From: Joseph Freegard
Sent: 01 September 2022 16:27
To: Dave Askwith
Cc: Planning; Michael Tagg; Jamie Wignall
Subject: 22/01045/FUL

This application for 'Change of Use of Agricultural Buildings into Two Dwellings with Associated Building Operations' at Forwood Farm on Wood Lane in Treswell is a re-submission of application 21/01255/FUL. Conservation objected to application 21/01255/FUL for the following reason:

Project: Barn & Stable Conversion
 Forwood Farm, Treswell,
 Retford, Notts
 DN22 0EE
 Title: Proposed Elevations

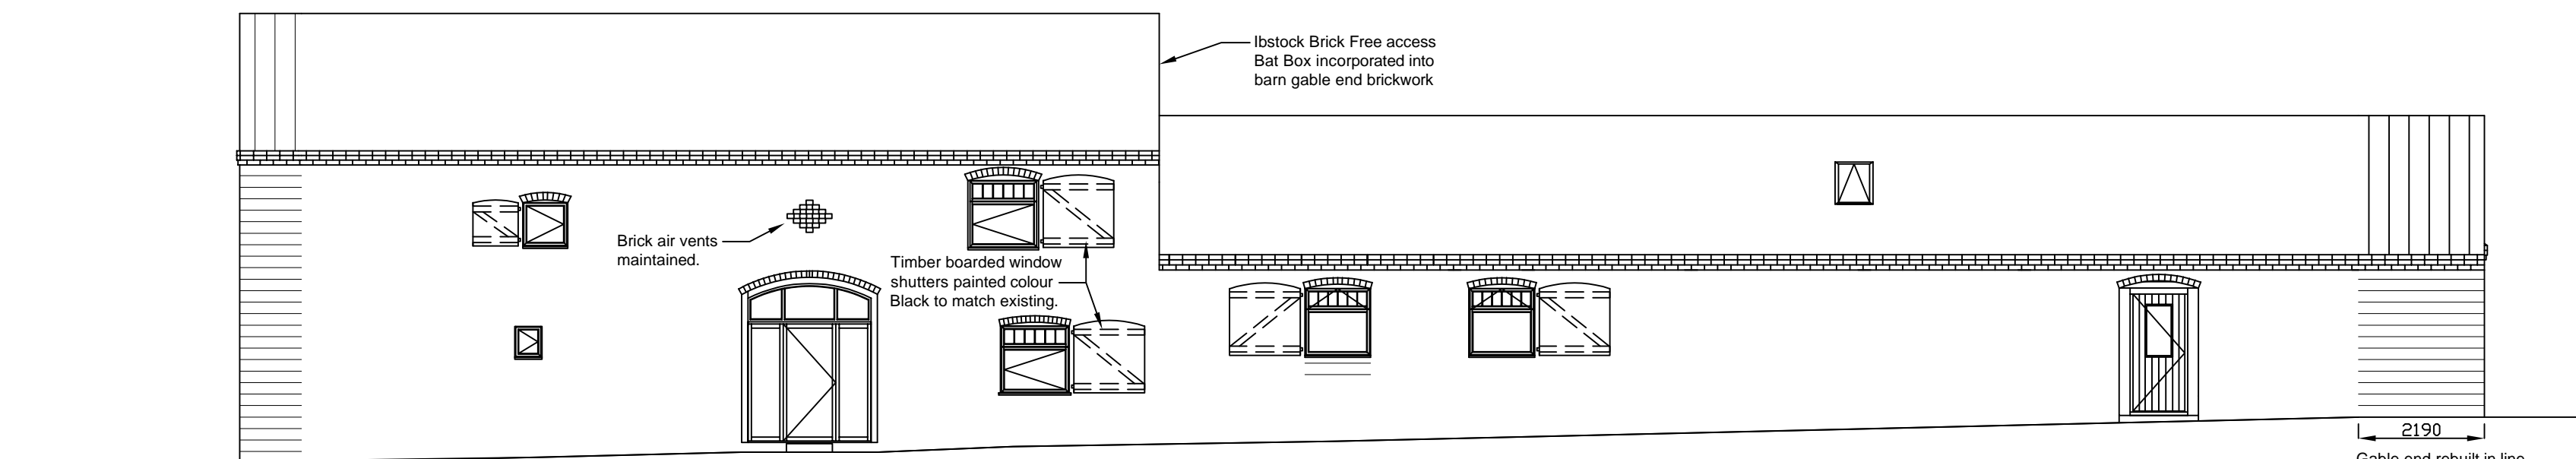
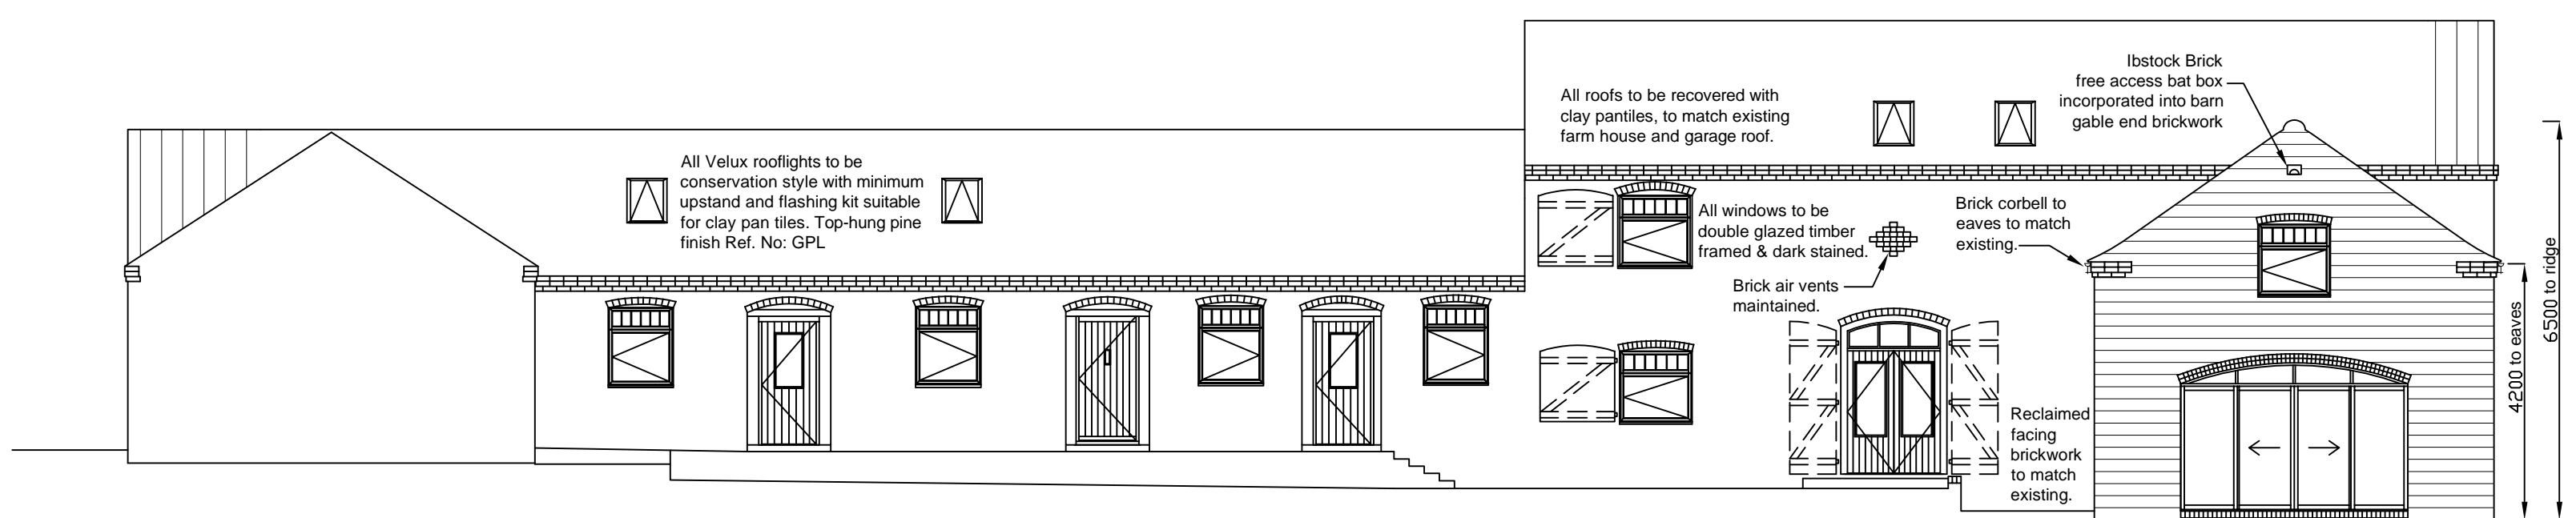
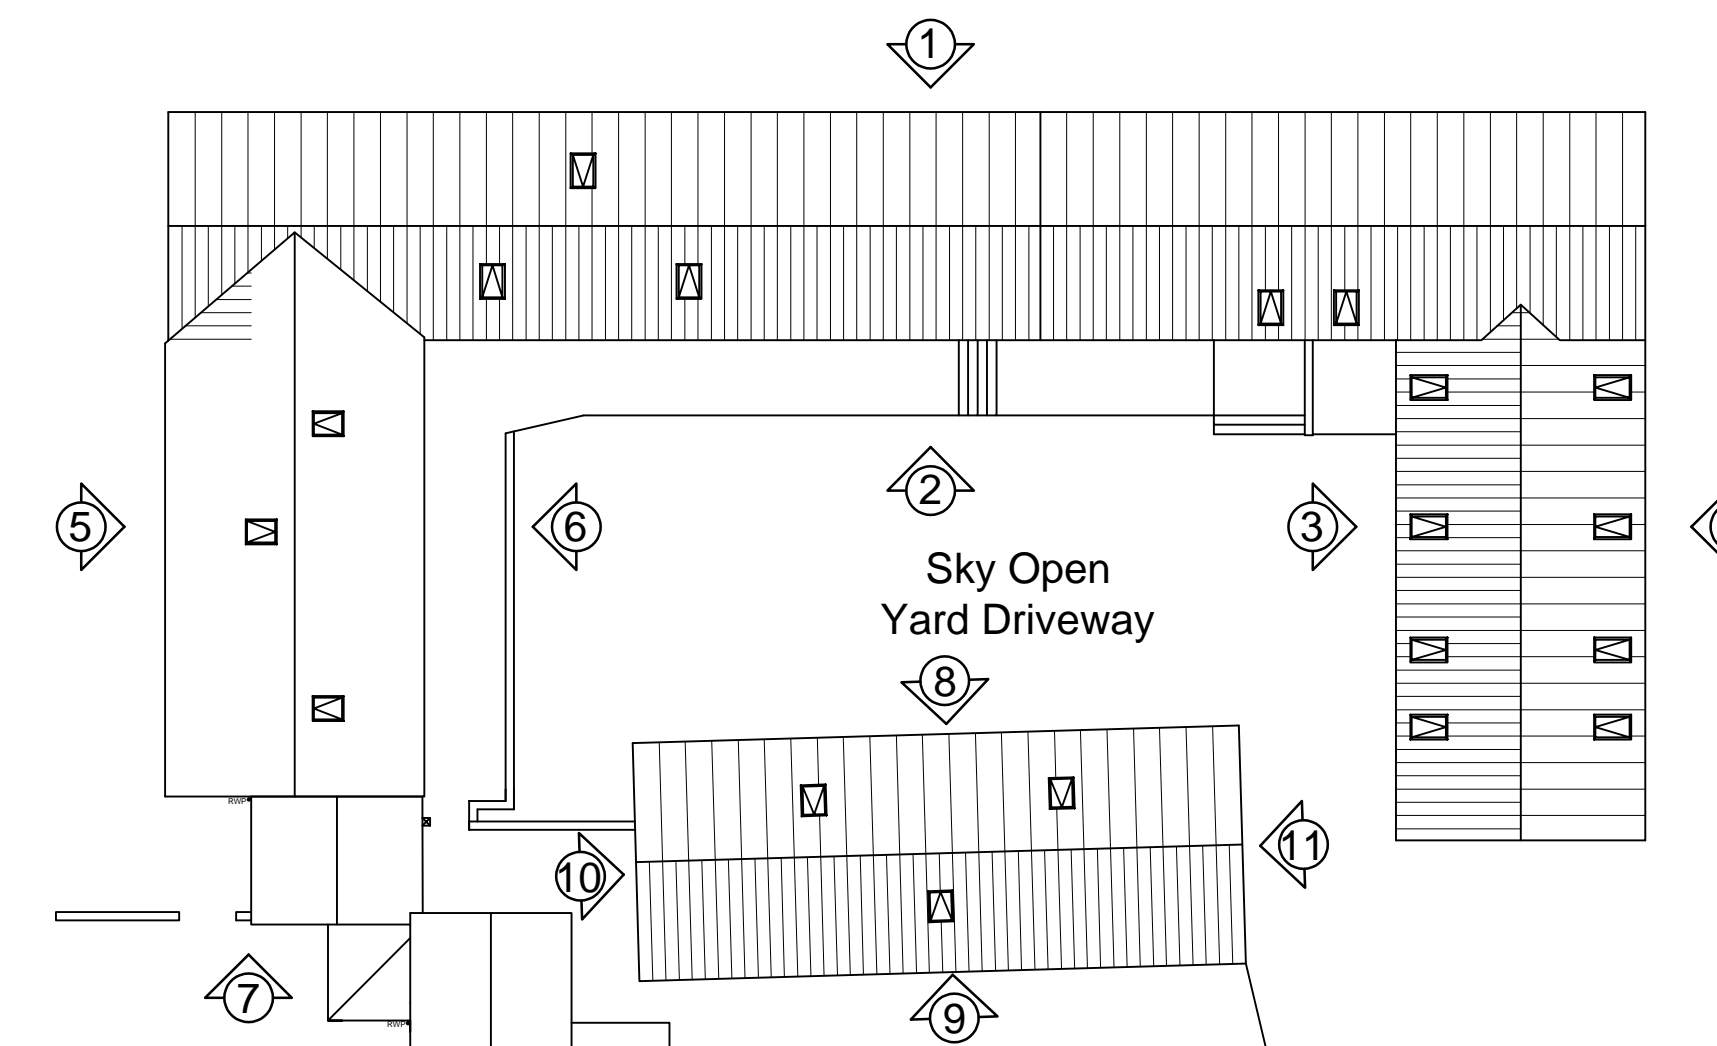
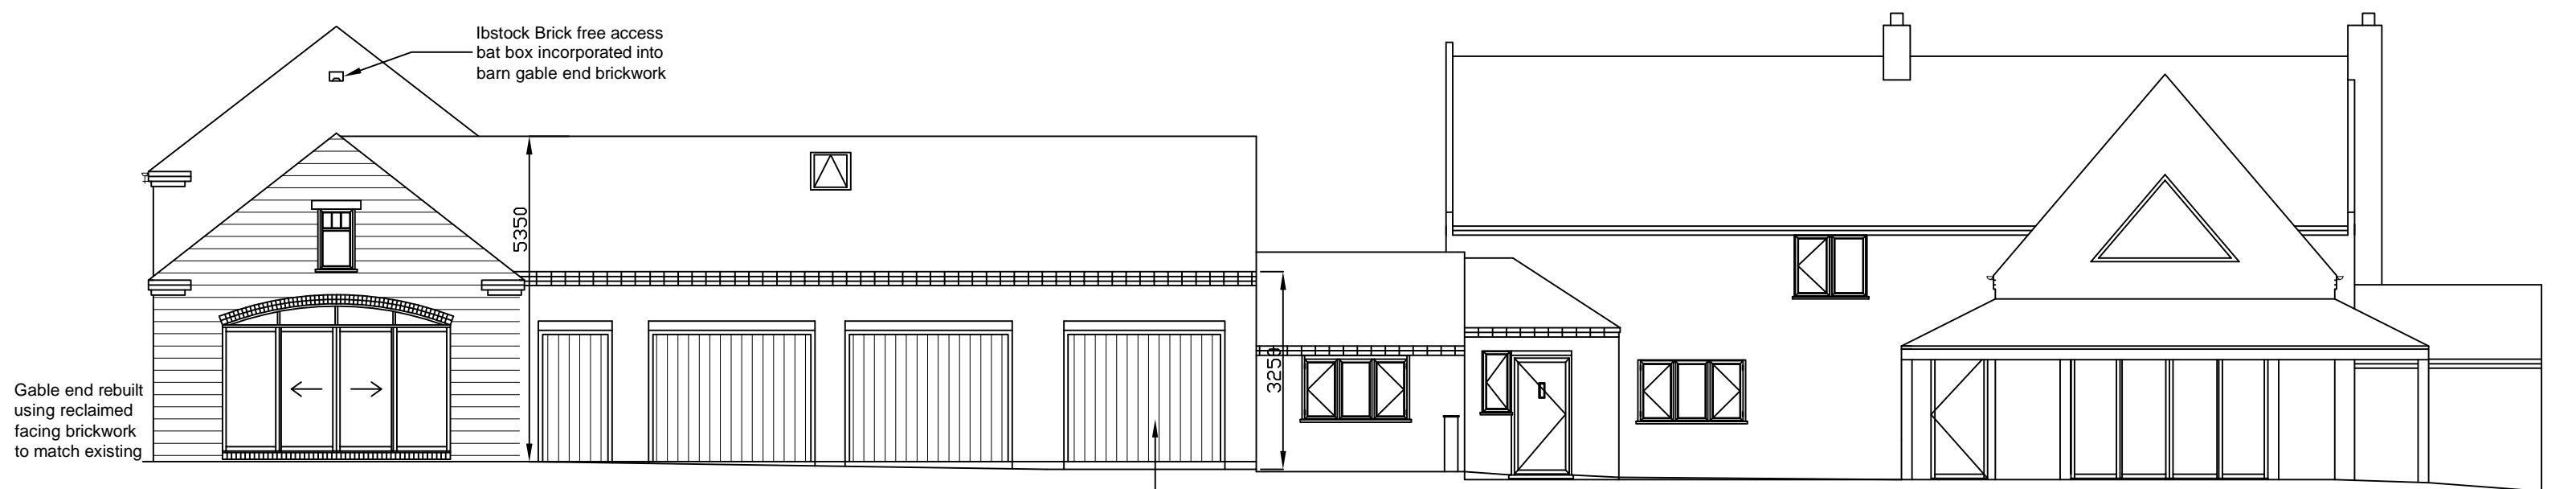
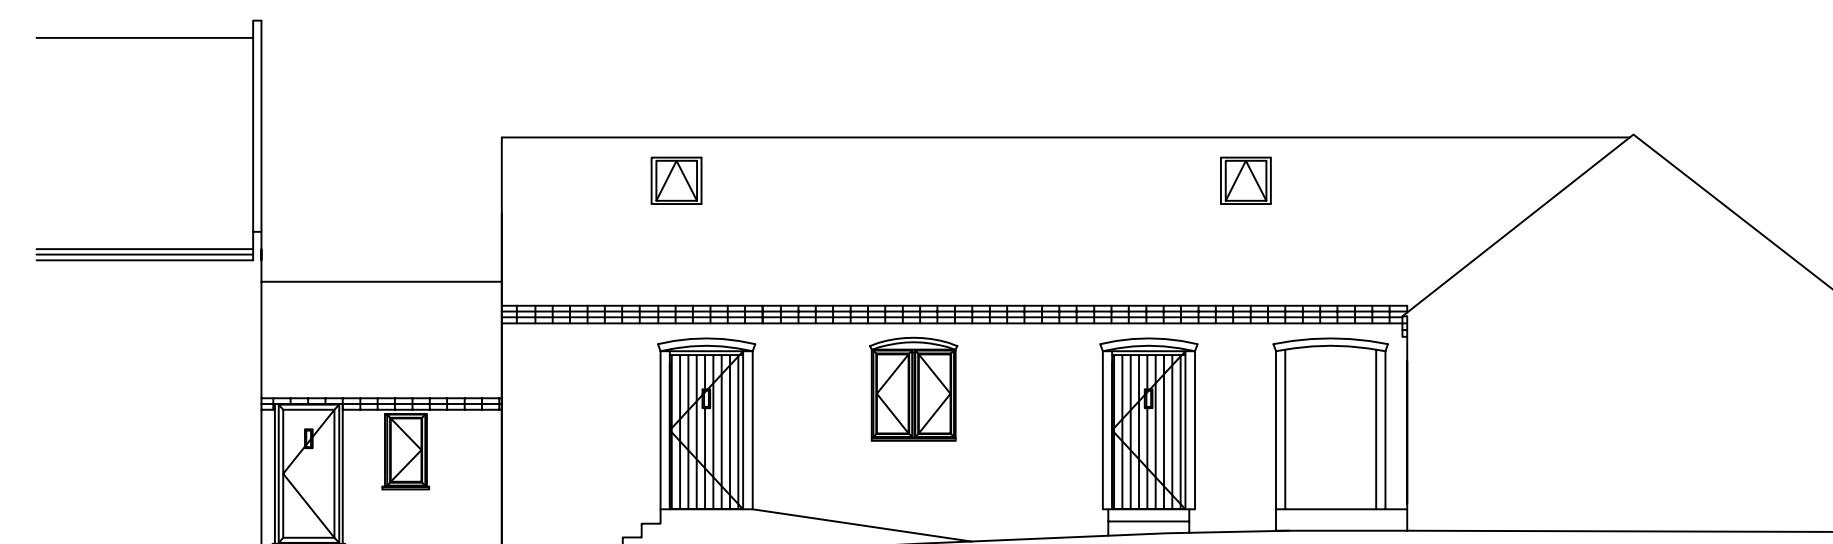
These revised proposals have addressed some of the concerns previously raised. New window and door openings have been kept to a minimum and the proposed fenestration largely comprises agricultural hopper style windows, and stable or cartshed style doors with five rooflights. These are likely to be acceptable, subject to full details being agreed. A modest extension to the north west facing elevation is proposed with mock cartshed opening and agricultural hopper style window above, but this would have minimal impact subject to materials and fenestration being agreed. However, a diamond ventilation slit to the south west facing elevation is proposed to be replaced by a window and it still appears that the south east facing gable end is to be re-built and extended slightly. This would result in the loss of features of significance, and the proposed ground floor openings within this extended gable end are considered to be very much domestic in appearance and would therefore be out of character on this agricultural range. These matters are a cause for concern, the level of harm caused would outweigh any other matters for NPPF purposes and there is no clear and convincing justification for the harm caused. As such, it is considered that amendments are required. It is suggested that all of the diamond shaped vents should be retained and internally glazed and that the existing south east facing gable end should be retained and repaired/re-built as necessary with appropriate agricultural style fenestration. Full details of any repair and rebuilding works would be required for consideration.

This current application still proposes the demolition of the cart sheds and the part demolition of the stables. The cart sheds are proposed to be replaced by a larger single storey garage building in reclaimed red brick with a pitched clay pantile roof. Three vertically boarded timber garage doors and two vertically boarded pedestrian doors are proposed to the north east facing elevation, and these would have segmental arches above. All other elevations would be blank, and the structure would have three rooflights and corbelled eaves. The stables are now proposed to be replaced by a one and a half storey structure rather than a two storey structure, which would also be in reclaimed red brick with a pitched clay pantile roof. The timber posts to the north west facing elevation would be replaced by a brick wall with timber boarded mock cartshed openings containing hopper style windows and a door. A mock cartshed opening and agricultural hopper style window are proposed to the south west facing gable, and three agricultural hopper style windows with shutters are proposed to the south east facing elevation. The structure would have eight rooflights, corbelled eaves and segmental arches to the windows and doors. Although the

structural survey submitted with this application does not state that these structures must be demolished, it is considered that the proposed replacement structures would be largely appropriate in terms of appearance subject to further details in relation to materials, windows and doors and other matters being agreed. On balance for NPPF purposes, it is considered that the benefits of bringing this agricultural range back into use would outweigh the harm caused by the demolition and replacement of the cart sheds and stables. As such, these aspects of the application are considered to be acceptable from a Conservation perspective subject to the aforementioned matters being agreed.

Amendments required: In accordance with the above comments, it is considered that amendments are required in relation to the conversion of the linear range.
